# CITY OF ALBUQUERQUE

November 17, 2023

**Re: Dutch Bros. Coffee**  
**2501 Juan Tabo Blvd. NE**  
**Request for Certificate of Occupancy**  
**Transportation Development Final Inspection**  
Engineer's Stamp dated 11-17-22 (H21-D004B)  
Certification dated 11-07-23

CP-401

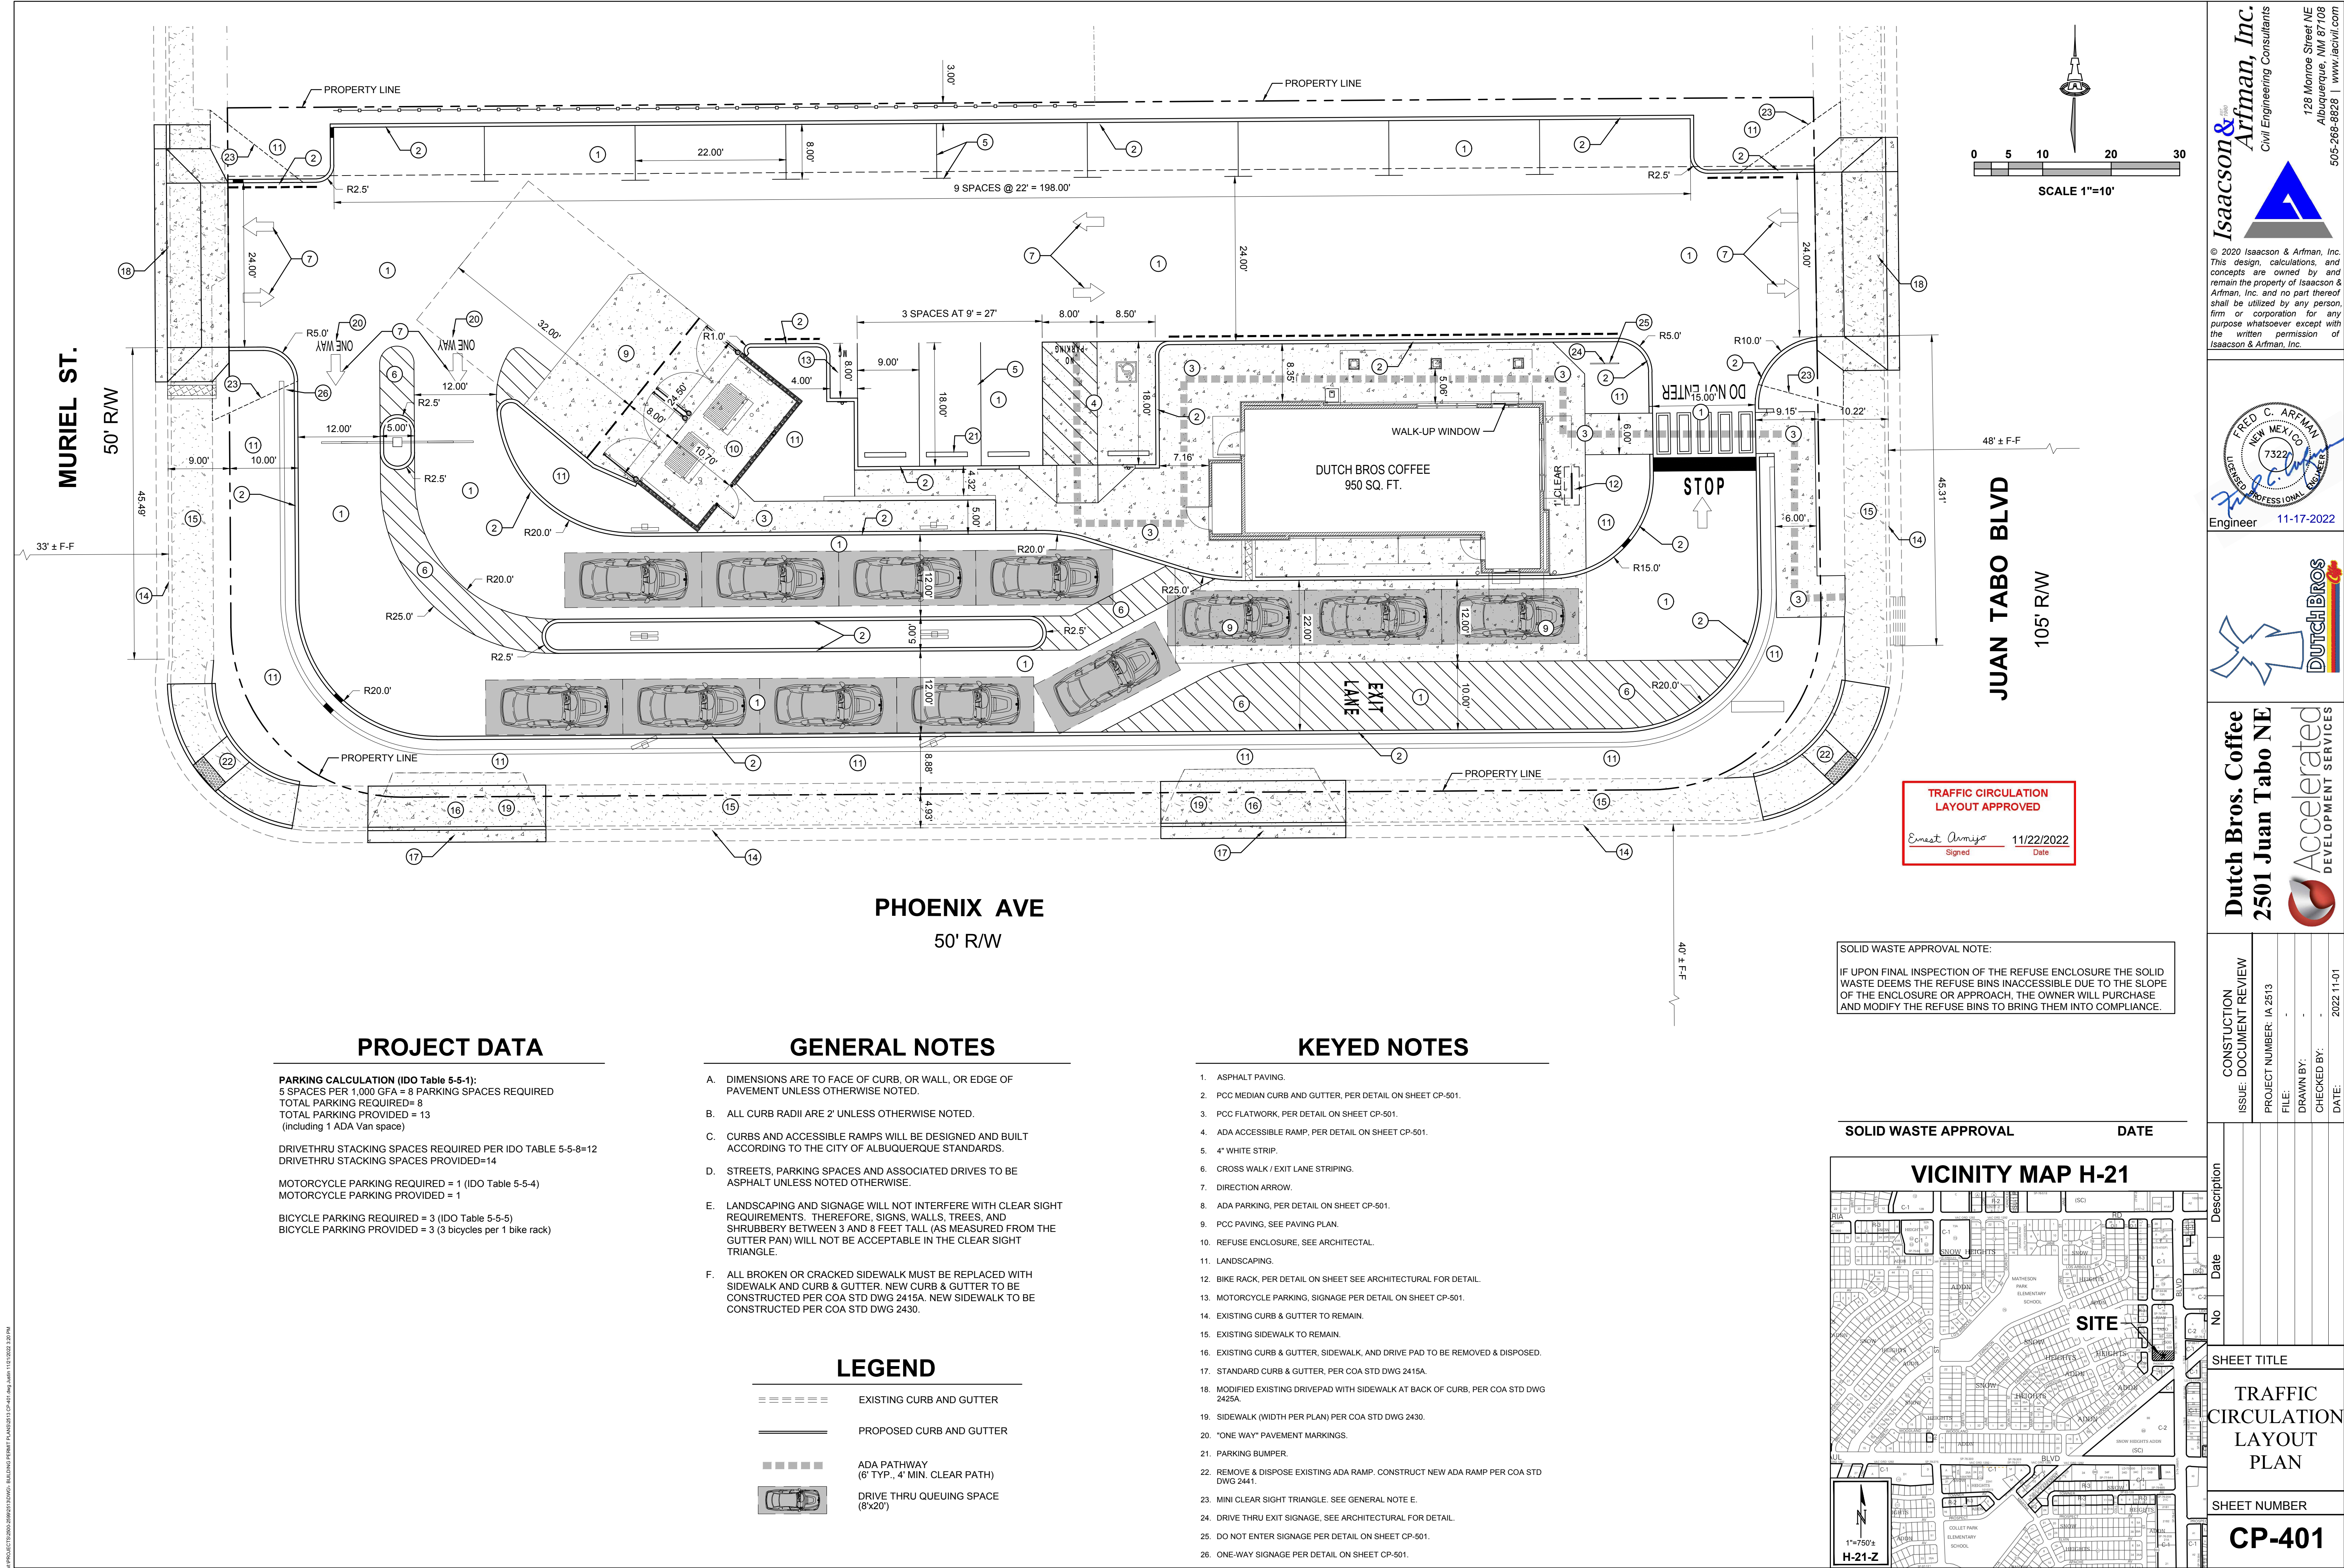
- Site access off Juan Tabo Blvd: Per city std the pedestrian pathway should be minimum 4 ft. wide. Per site visit the pathway was only 3 ft. wide. Please provide 4 ft. pathway.

- Per site visit, the new sidewalk off Phoenix Ave. has a cross slope range between 2.8% and 3.4%. Please note that maximum allowable cross slope should be 2%.
